Ribble Valley Borough Council
Housing & Development Control

Application no: **3/2020/0579**

Address: **Bowland Wild Boar Park Wardsley Road Chipping PR3 2QT**

Proposal: **Change of use of land to erect nine holiday lodges with parking and an associated package sewage treatment plant.**

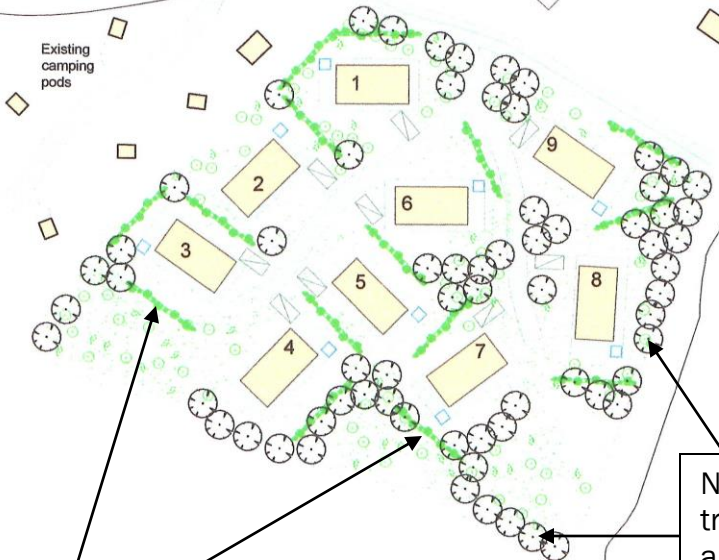
Under the previous planning application 2016/0027, the proposal required 6 parking spaces. The current planning application refers to 8 existing parking spaces with 9 proposed parking spaces totalling 17 parking spaces. However, in accordance with the proposed site plan, 22 parking spaces are proposed and should the proposal require 17 parking spaces in total then this should be reflected within the proposed site plan.

HAVANA CENTRE LOUNGE

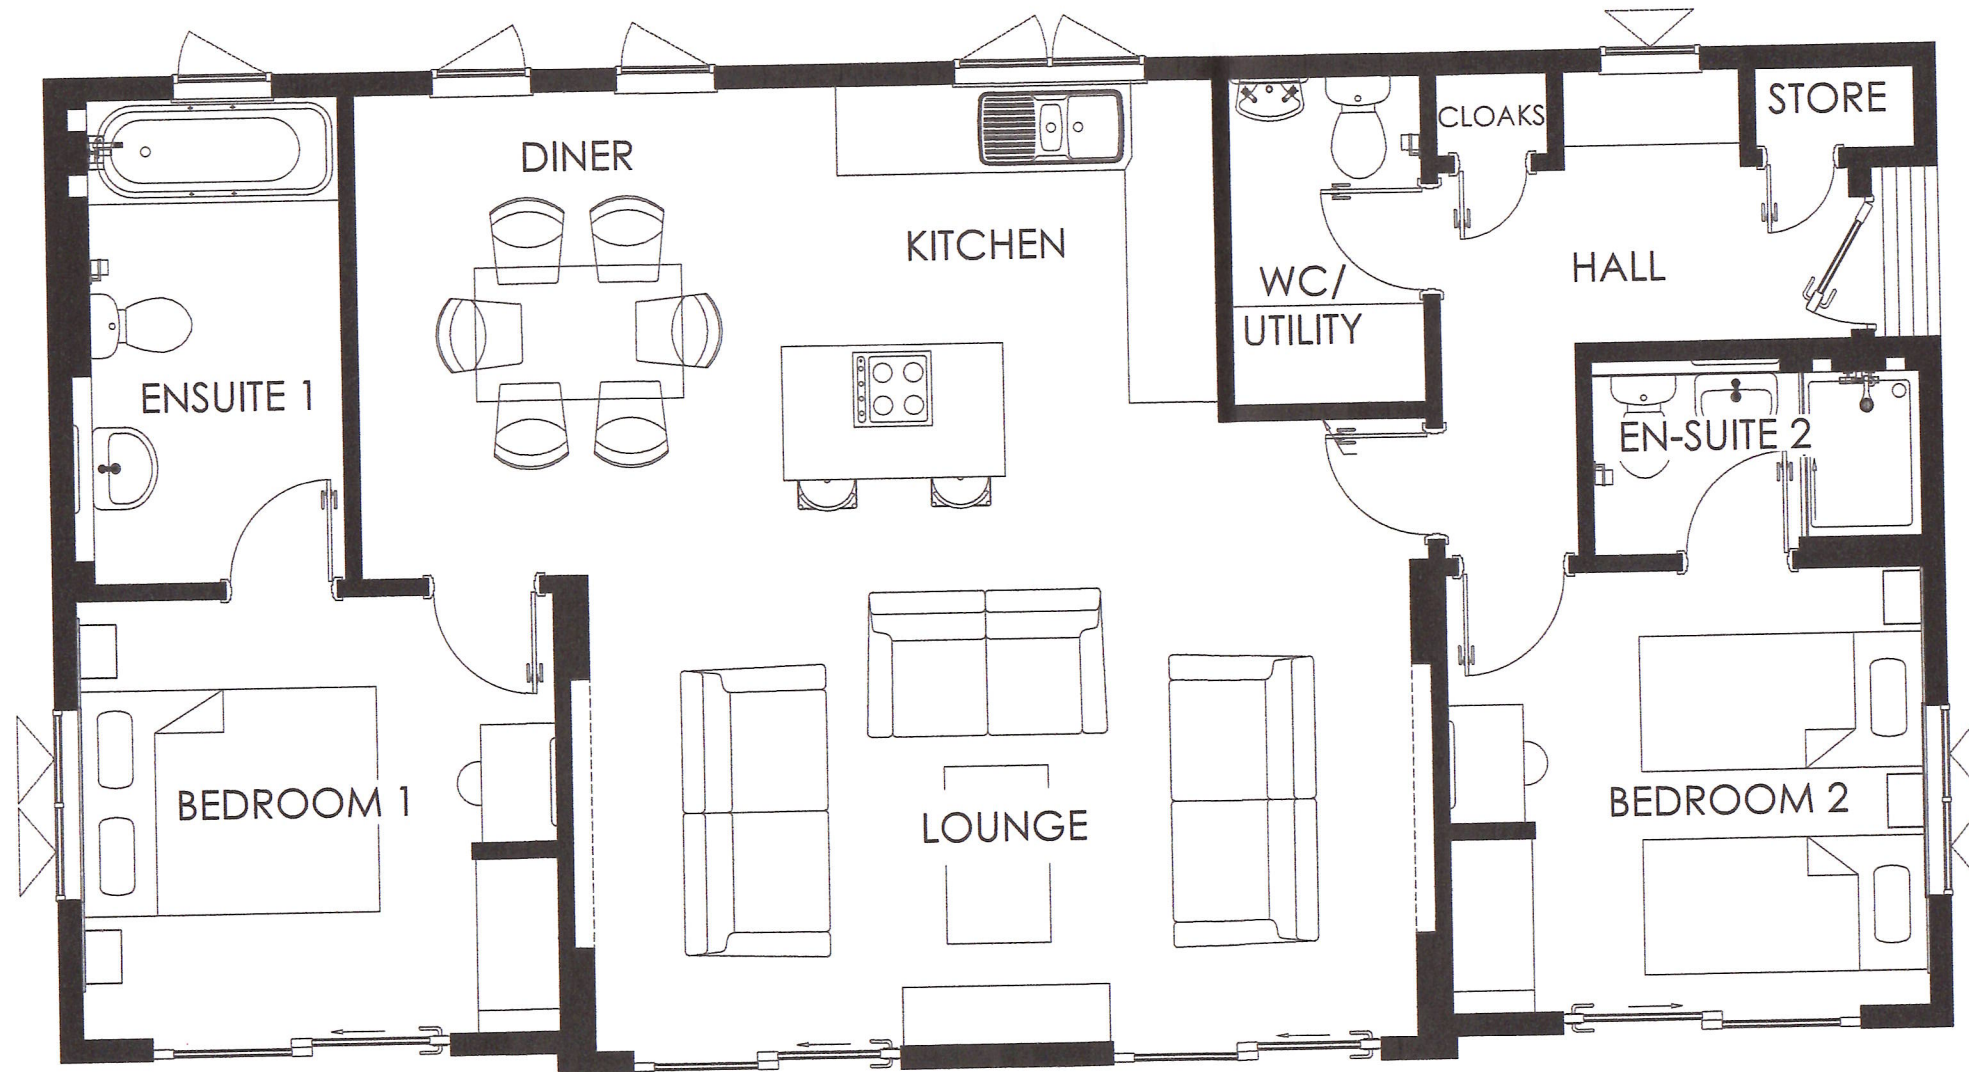
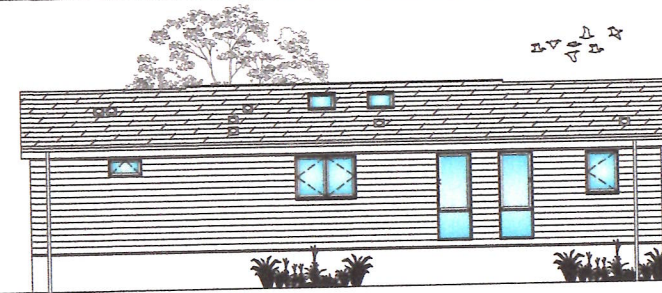
The proposed change of use of land to erect nine holiday lodges with parking and an associated package sewage treatment plant is to be situated adjacent to an existing colony of pods. The existing site entrance is suitable for the proposal, and the traffic generation is expected to be minimal and outside of peak periods. However, the Local Highway Authority must draw our attention towards any abnormal loads being placed on the surrounding highway network given the individual lodges will measure 12.8 metres x 6.7metres.

The submitted design and access statement refers to the development as "a proposal to erect 9 timber lodges", which would give the impression the individual lodges are to be assembled on site. However, in the same document, in the context of site,

Whilst the Local Highway Authority would not raise an objection to the proposal, we would need to be satisfied that no highway safety concerns would arise from the proposal in terms of any abnormal loads being introduced to the surrounding local highway network and therefore the lodges should be erected on site as opposed to being transported and installed/removed to/from the site and that any materials being brought to site should be well demonstrated in a construction management plan and transport routing plan.

1. No development shall take place, until a construction management plan and transport routing plan has been submitted to and approved in writing by the Local Planning Authority In consultation with the Local Highway Authority. The approved statement/plan shall be adhered to throughout the construction period and in perpetuity of the development thereafter. It shall provide for:
 - The parking of vehicles of site operatives and visitors
 - The loading and unloading of plant and materials
 - The storage of plant and materials used in constructing the development
 - The erection and maintenance of security hoarding
 - Wheel washing facilities
 - Measures to control the emission of dust and dirt during construction
 - A scheme for recycling/disposing of waste resulting from demolition and construction works
 - Details of working hours
